**A1 Birtley to Coal House**  
**Scheme Number: TR010031**

**EXA/D4/018 Applicant's Responses to ExA's Second  
Written Questions**

**Applicant's Responses to ExA's Second Written Questions**

<b>Version</b>	<b>Date</b>	<b>Status of Version</b>
Rev 0	20 April 2020	For Issue

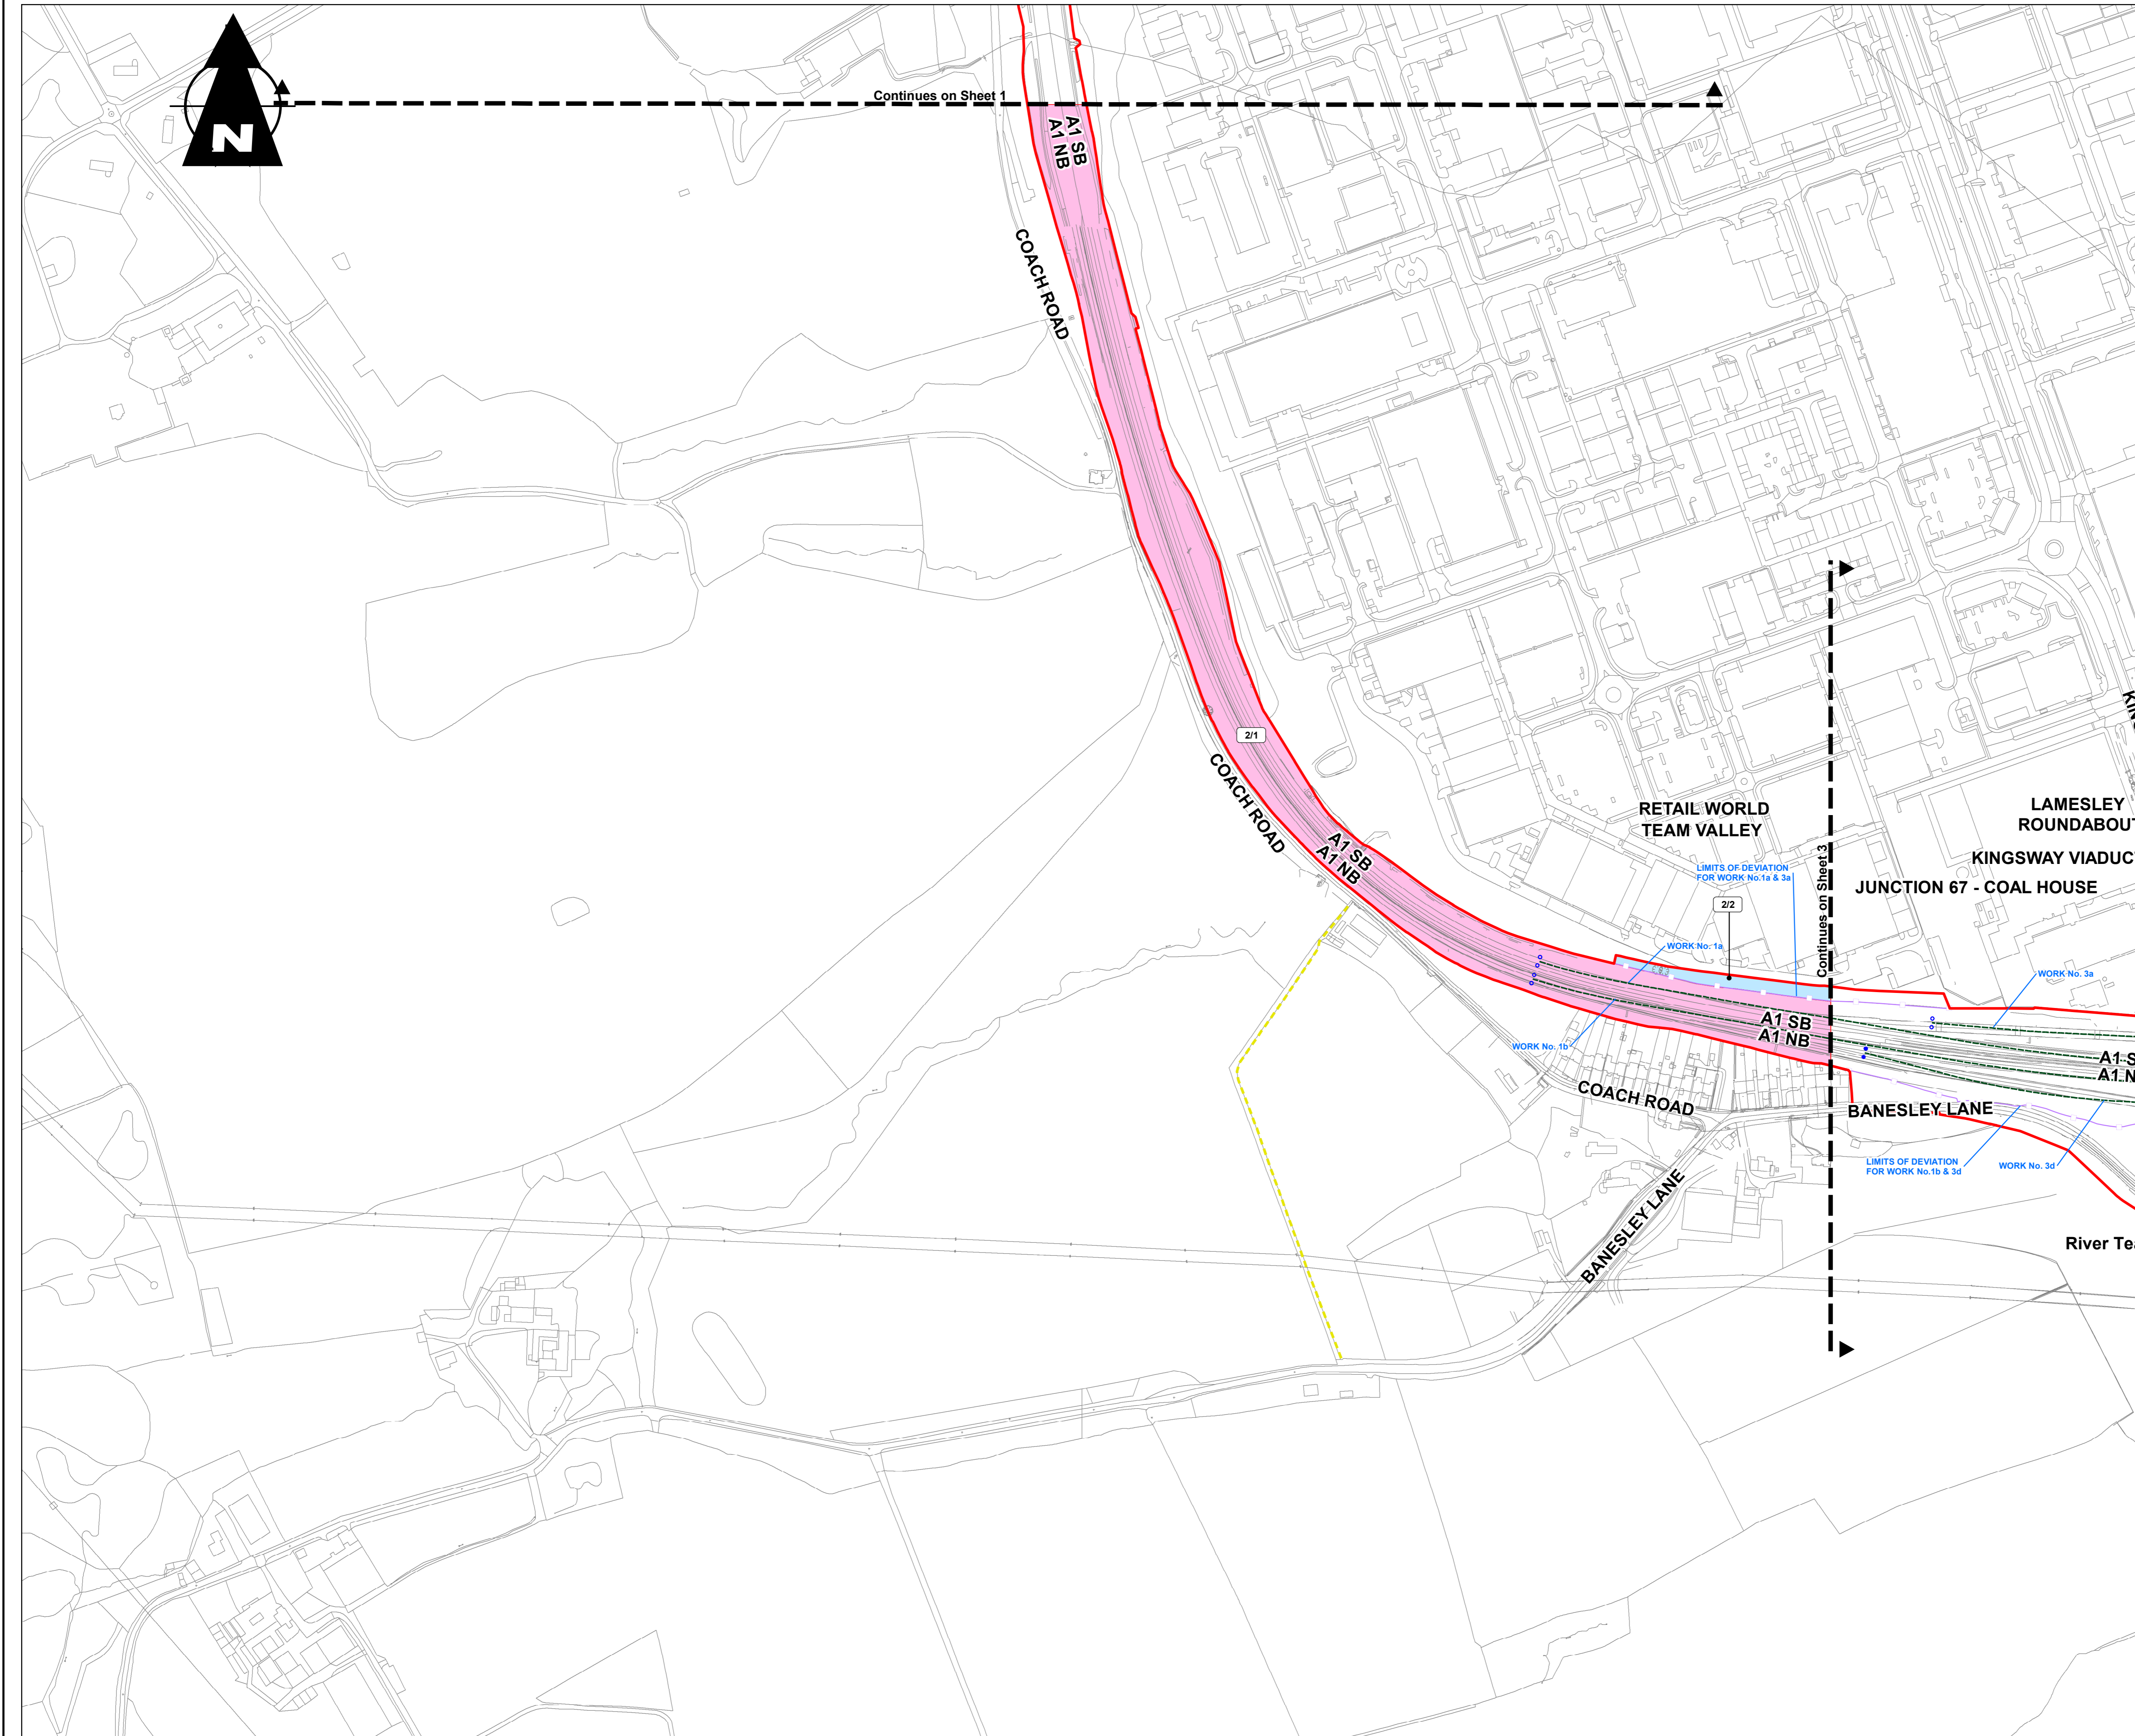
2.0.10	The Applicant	<p><b>Sheet 3 of the Works Plans [APP-007]</b> includes the Limits of Deviation for a) Works Nos. 9, 10, 13, 14, 15, 16 and b) Work No. 22.</p>	<p>The works listed relate to Statutory Undertaker apparatus. It is usual for Limits of Deviation to be applied to Statutory Undertaker diversions to allow the variations to the locations during design development to avoid</p>

Ref No:	Question to:	Question: General and Cross-topic Questions	Response:
		<p>Please provide justification for the extent of land within these Limits of Deviation?</p>	<p>or connect into existing apparatus (where the location is unknown); due to unknown ground conditions; and due the potential for other unknown underground apparatus to be present. This is particularly relevant for the Scheme, which is in an area of extensive historic mining activity. A 10m limit of lateral deviation has been applied to Works Nos. 9, 13, 14, 15, 16 and 22 to allow for variations to the proposals during design development. The 10m limits are comparable or less than those provided on other Nationally Significant Infrastructure Projects. Where there are additional factors which may require variation in the location of the diversion these are recorded below.</p> <p>For work No. 9, in addition to the above, the diversion may be varied due to variations to the proposed transfer site and other proposed Statutory Undertaker diversions.</p> <p>For work No. 13, in addition to the above, the diversion may be varied due to variations to the proposed transfer site and other proposed Statutory Undertaker diversions.</p> <p>For work No. 14, in addition to the above, the diversion may be varied due to variations to the proposed gas transfer site, other proposed Statutory Undertaker diversions and variation to the location of the proposed ditch.</p> <p>For work No. 15, in addition to the above, the diversion may be altered due to variations to the proposed transfer site, other proposed Statutory Undertaker diversions and variation to the location of a proposed ditch / culvert. There are two locations where LoD greater than 10m are proposed, these are to accommodate an alternate alignment to pass through a span of the two viaduct options.</p> <p>For work No. 16, in addition to the above, the diversion may be varied due to variations to the proposed transfer site and other proposed Statutory Undertaker diversions.</p> <p>The limits of deviation for Work No. 10 are to allow flexibility during final design development of the Northern Gas Network (NGN) gas transfer site. With the exception of plot 3/3jj the land affected by this work is owned by NGN and therefore these limits do not disadvantage any other parties. Approximately 5m width of plot 3/3jj is included to allow for the connection to existing infrastructure within Work No. 9 to be included within the site.</p> <p>For Work No. 22, there are no additional factors to the above (ground conditions and potential for other apparatus to be present) which may require variations.</p>
